**Land Approx 1 Mile From J9 East Of M40 Part Of
M40 Through Chesterton Parish Chesterton**

22/01599/DISC

Proposal: Discharge of Conditions 6 (colours and materials of any water slide, wolf, or other external built feature), 24 (footpath specification details) and 25 (Construction Traffic Management Plan) of 21/04158/F

45408 SK-29A

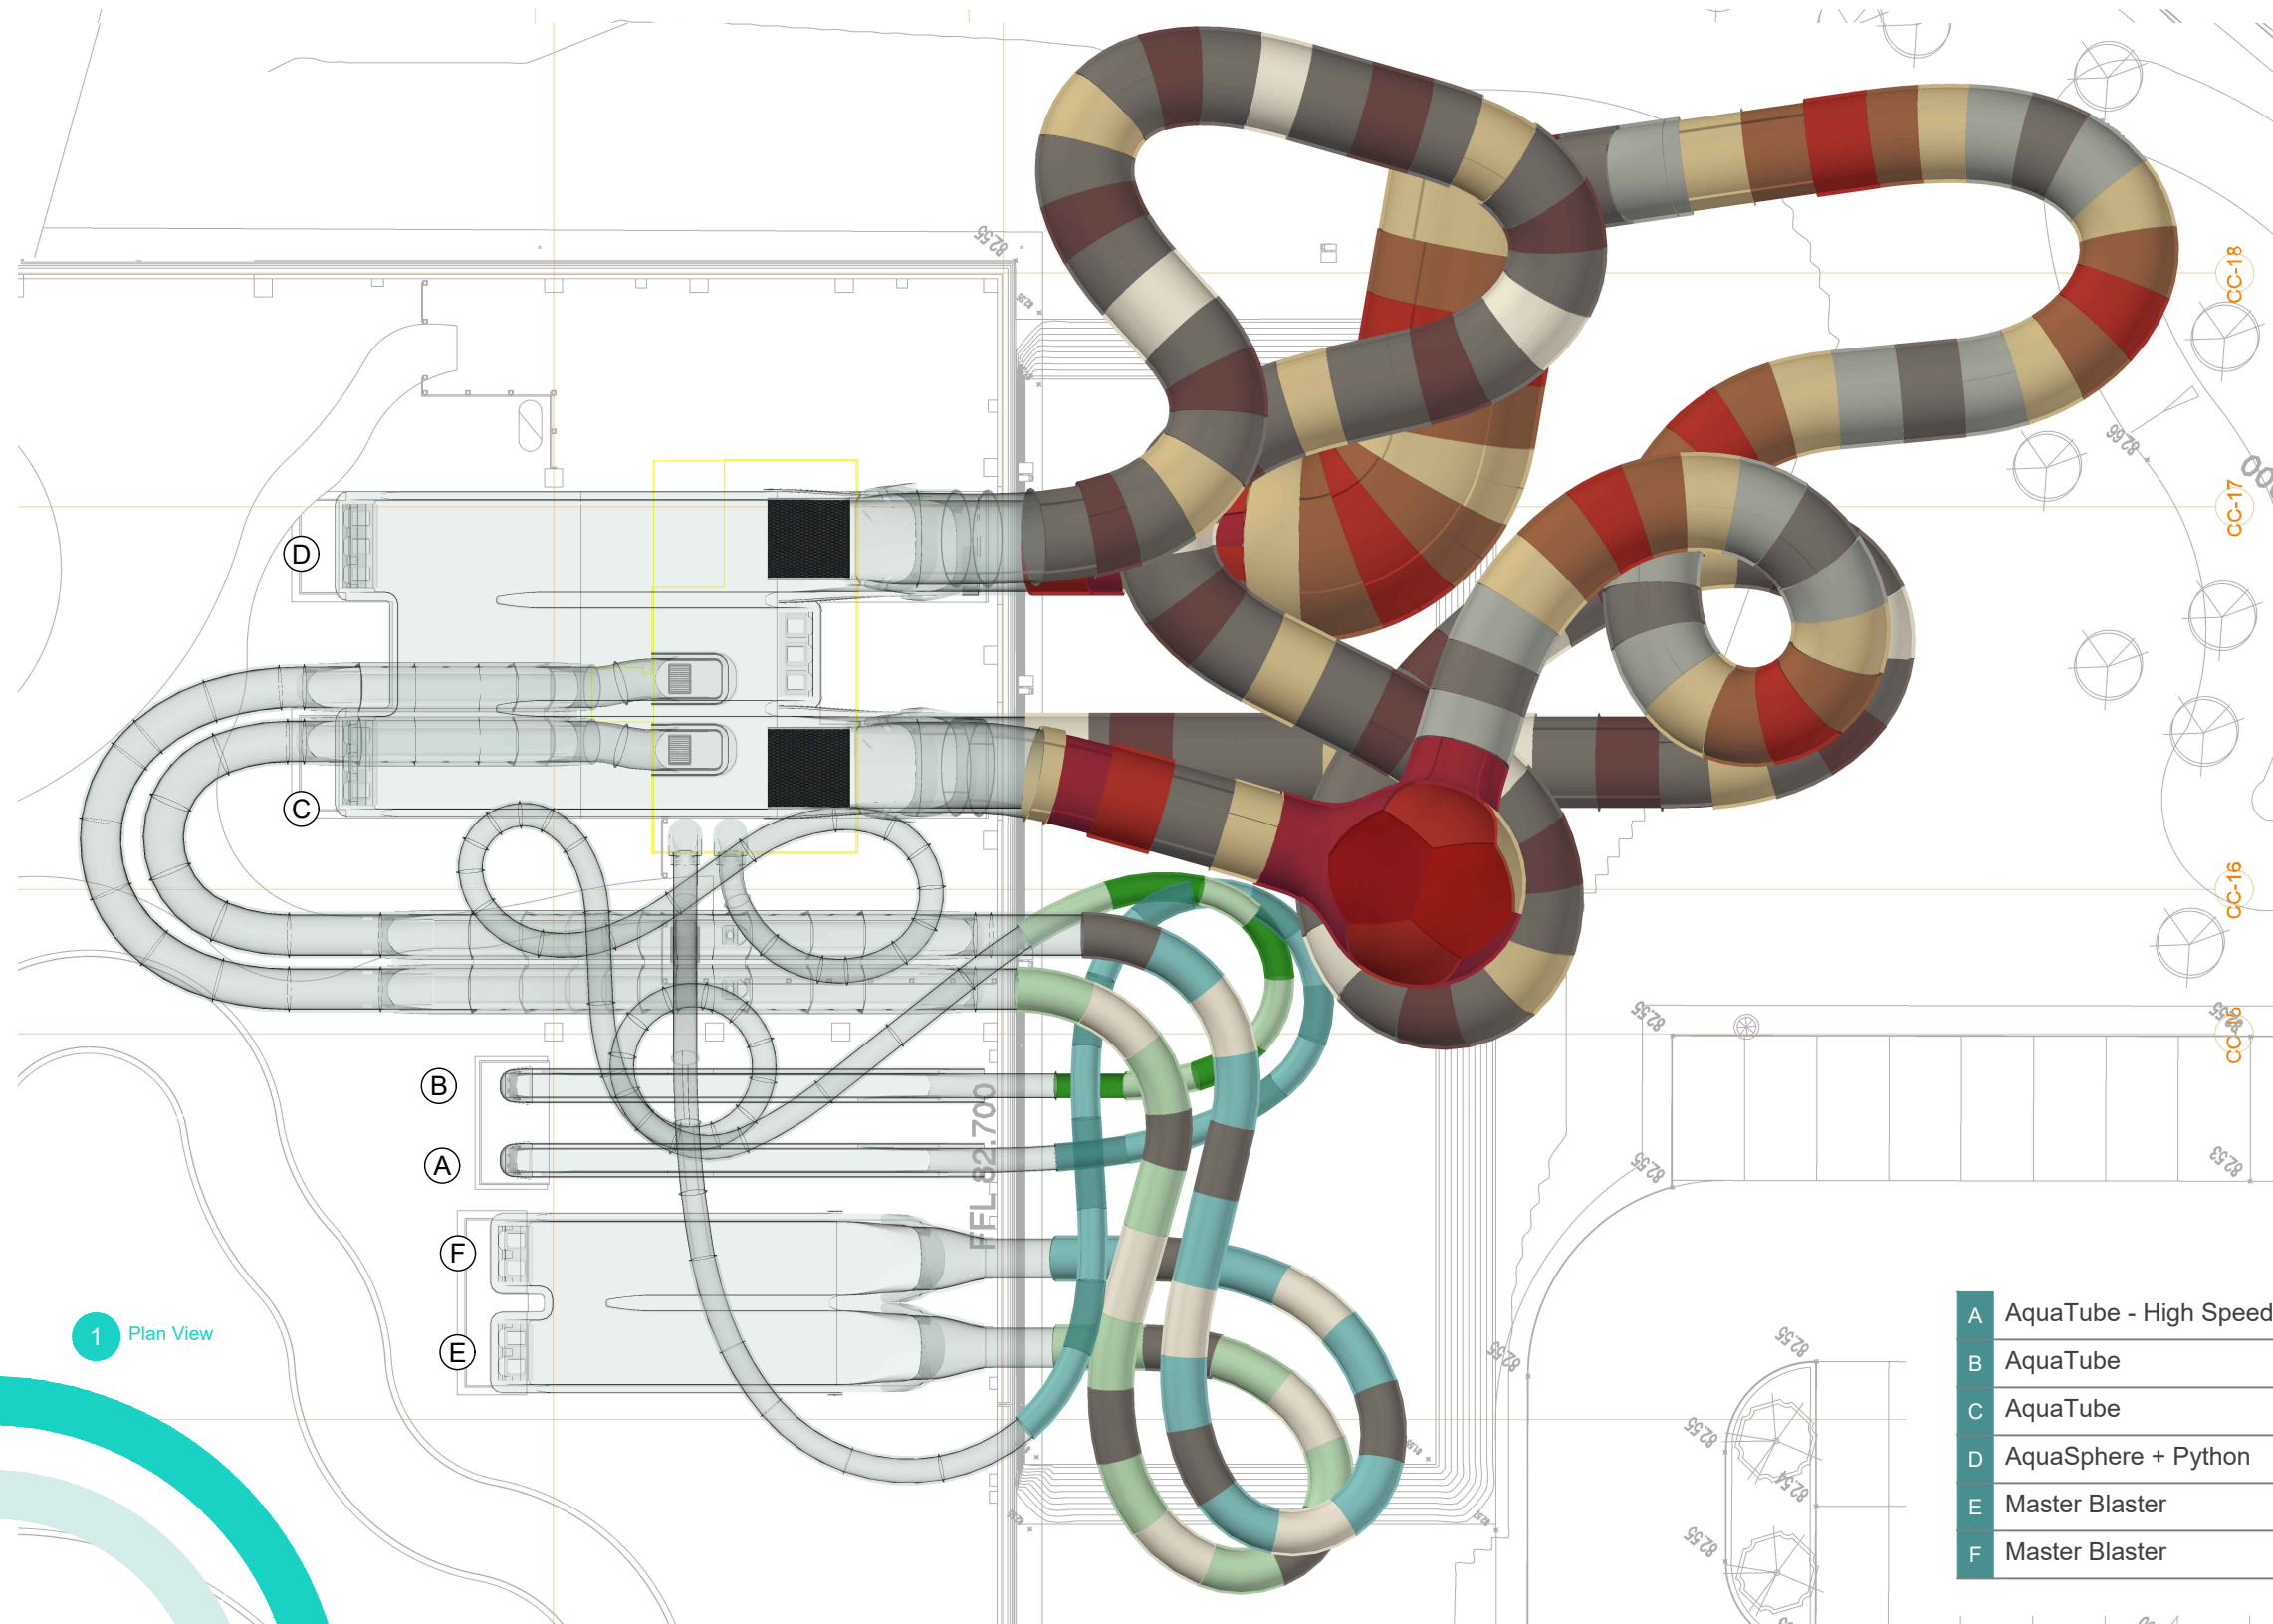
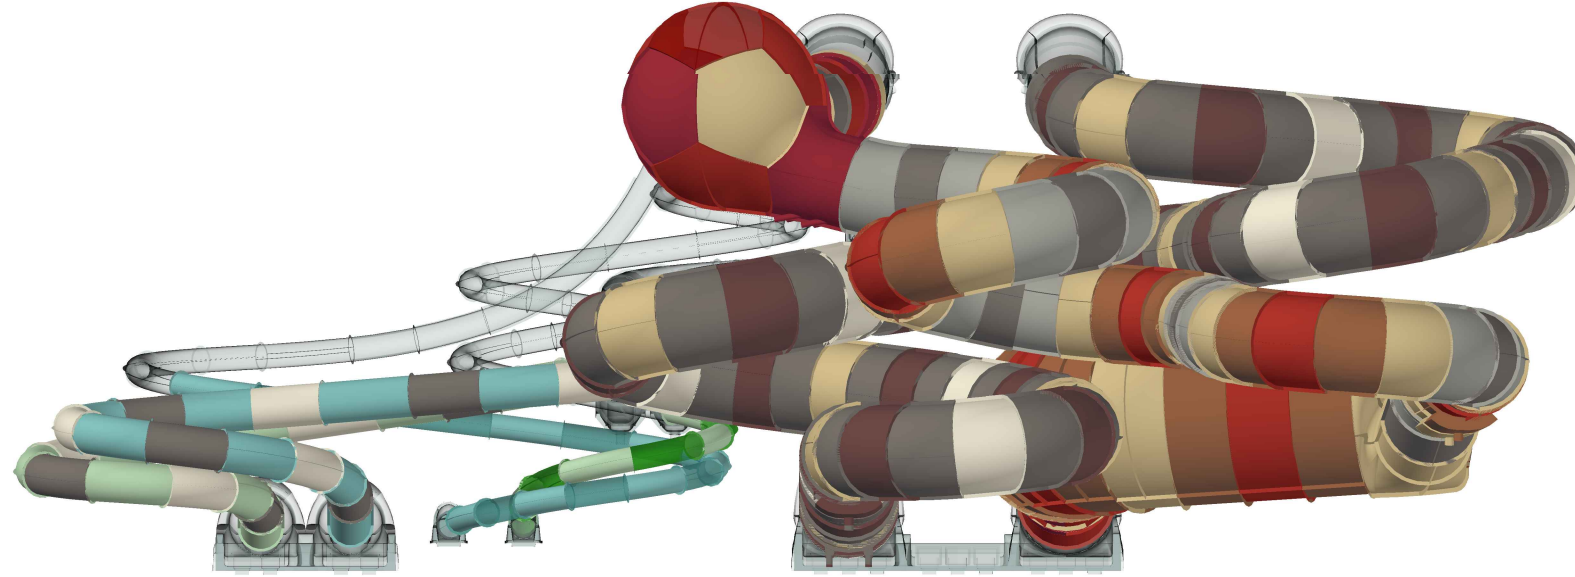
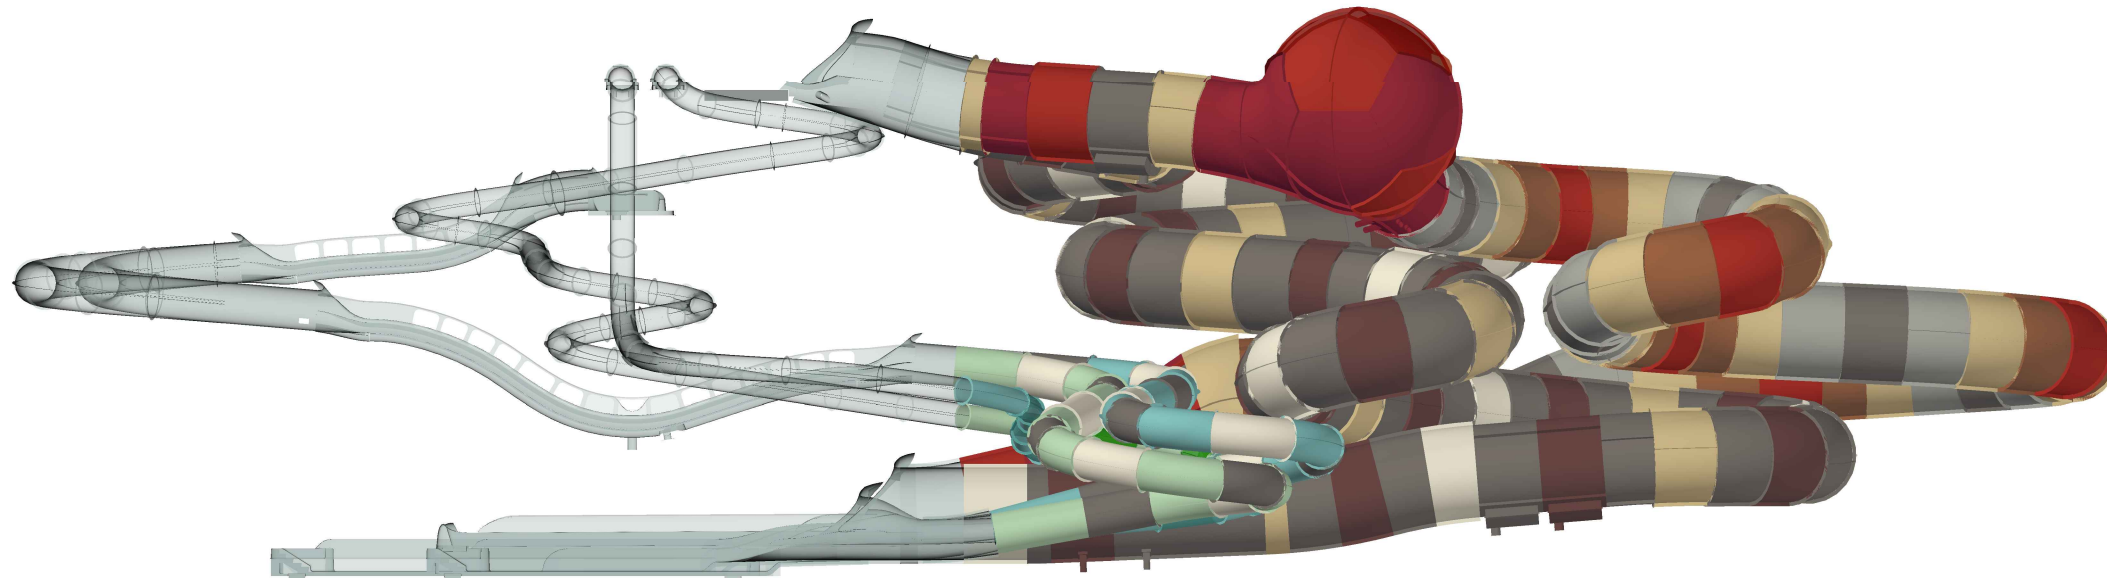
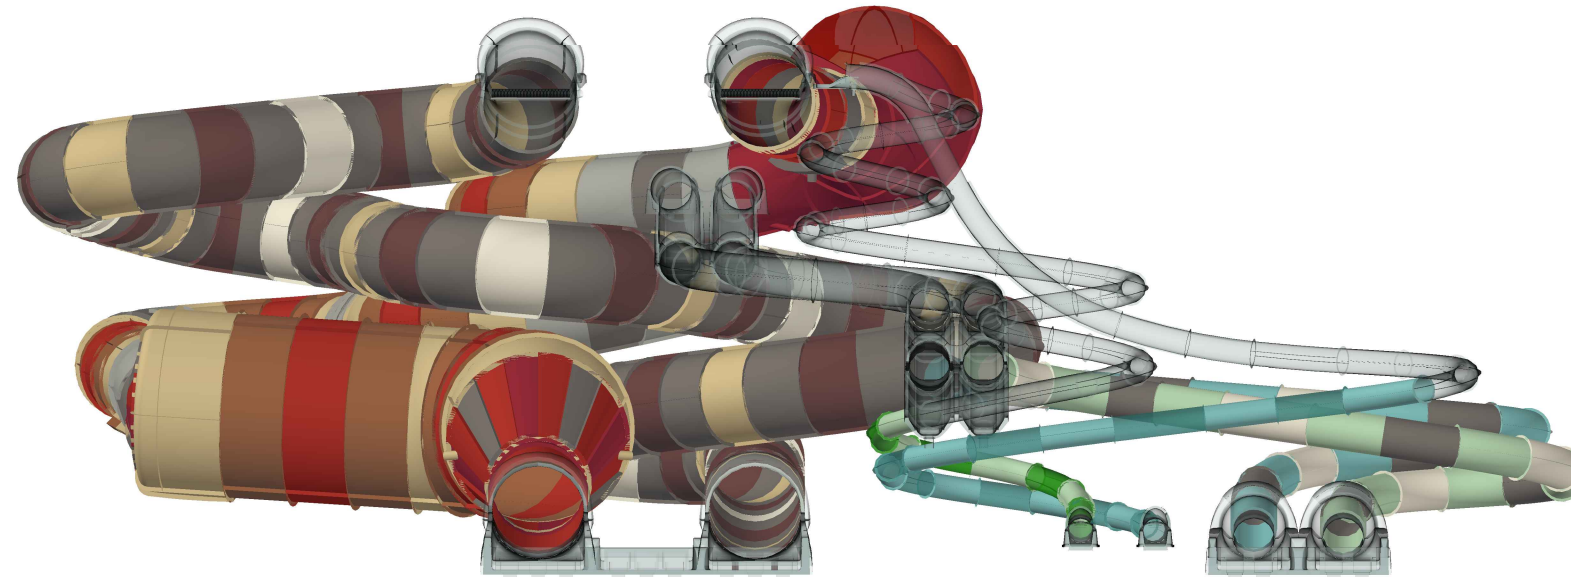
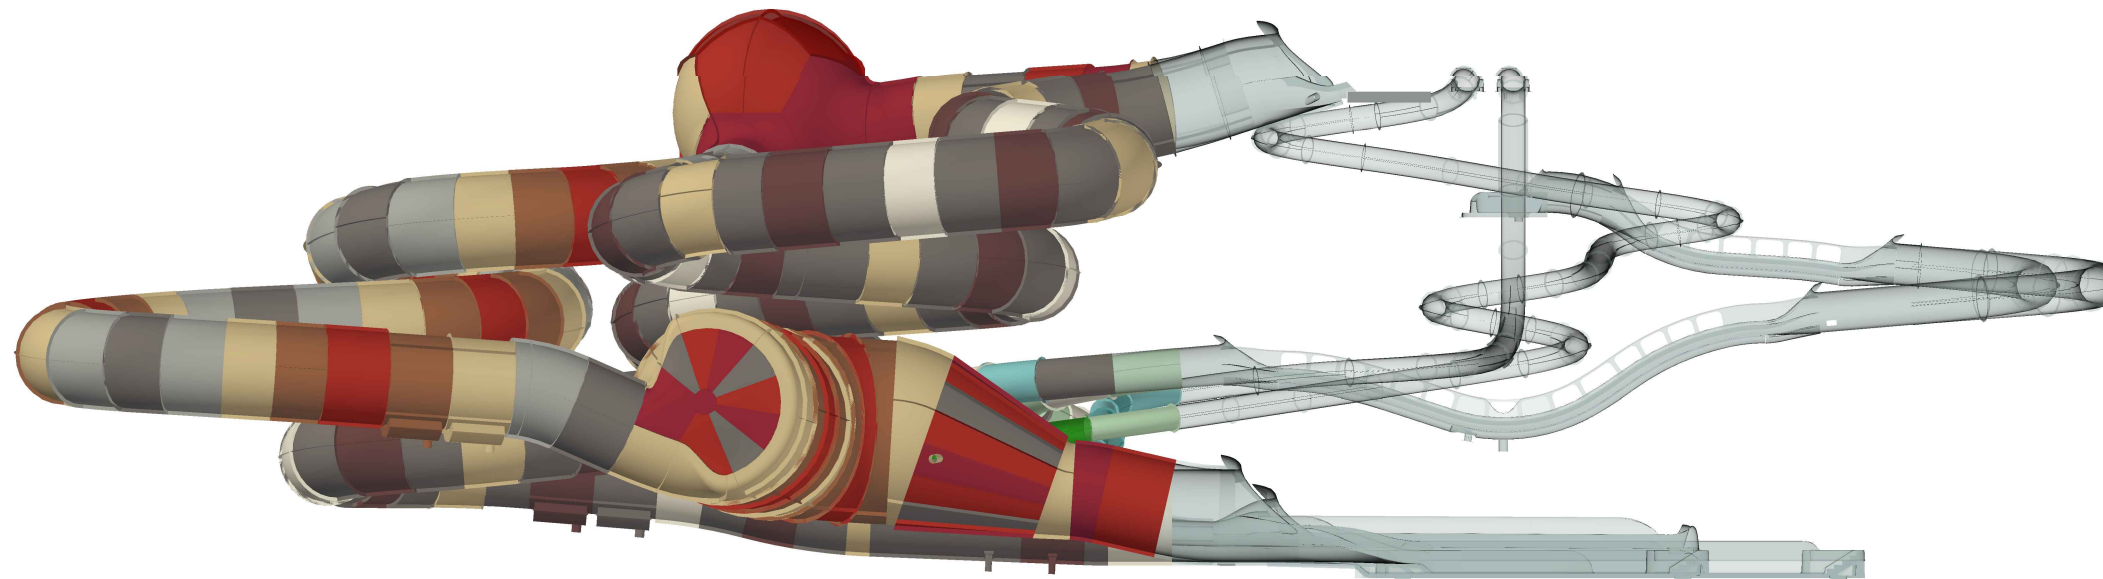
- 6.1. The waterslide colours are the following; beige, oyster white, translucent red, tomato red, coral red, translucent green, pastel green, light green, translucent aquamarine, beige grey, pebble grey, red brown and orange brown. The Landscape Officer has no objection to the proposal in regards to the flue details. I consider the colours will blend in with the site and its surroundings, therefore the flue details are acceptable.

Wolf Sculpture Drawing Pack (19095934) and Flume Details 4540829 Rev A received 30 May 2022.

001 TYPICAL HARD DETAIL - GRAVEL FOOTPATH
 005 SECTION

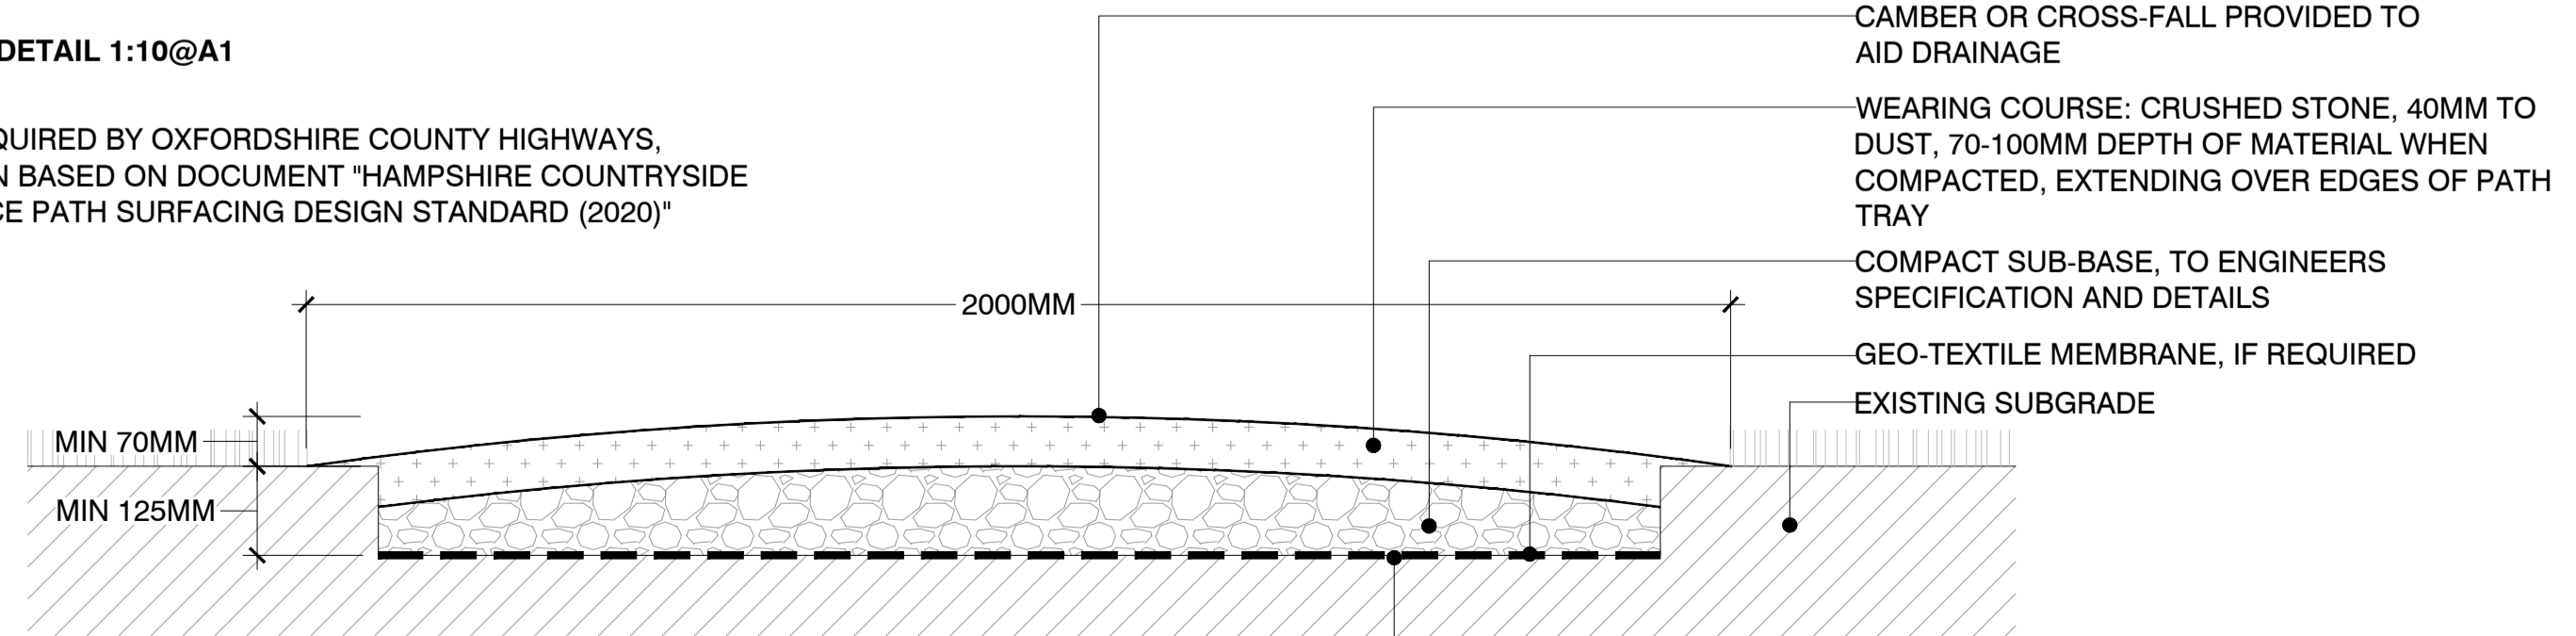
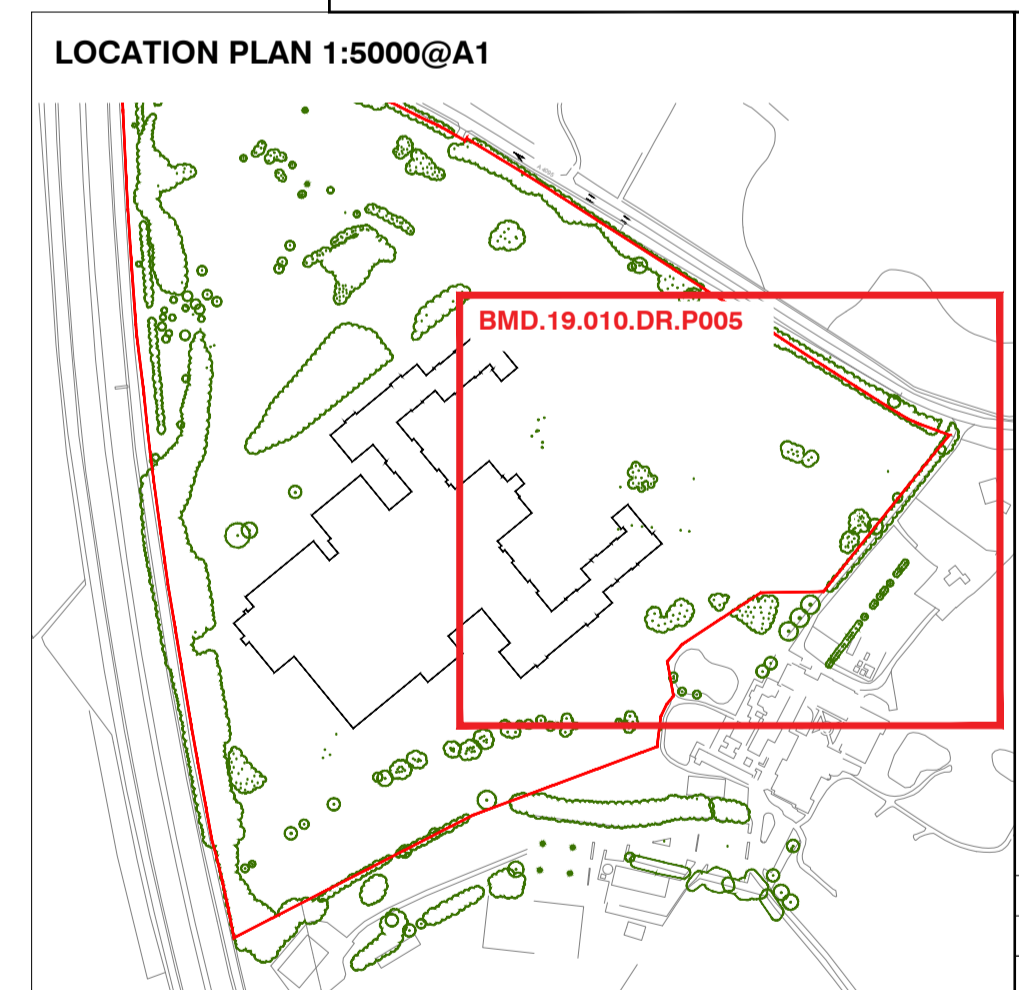
- 2.5. The applicants have provided additional information following comments from the Rights of Way officer. They have updated the plans so the plans now show crushed stone.

- 6.3. Condition 24 relates to the surfacing of the public footpath. They have provided additional information to ensure it is crushed stone, as the drawings originally had been altered in error. They have also amended the size of crushed stone to 40mm from 70mm.

Public Right of Way Location and Detail Plan (BMD.19.010.DR.P005 Rev C)
received 26th October 2022
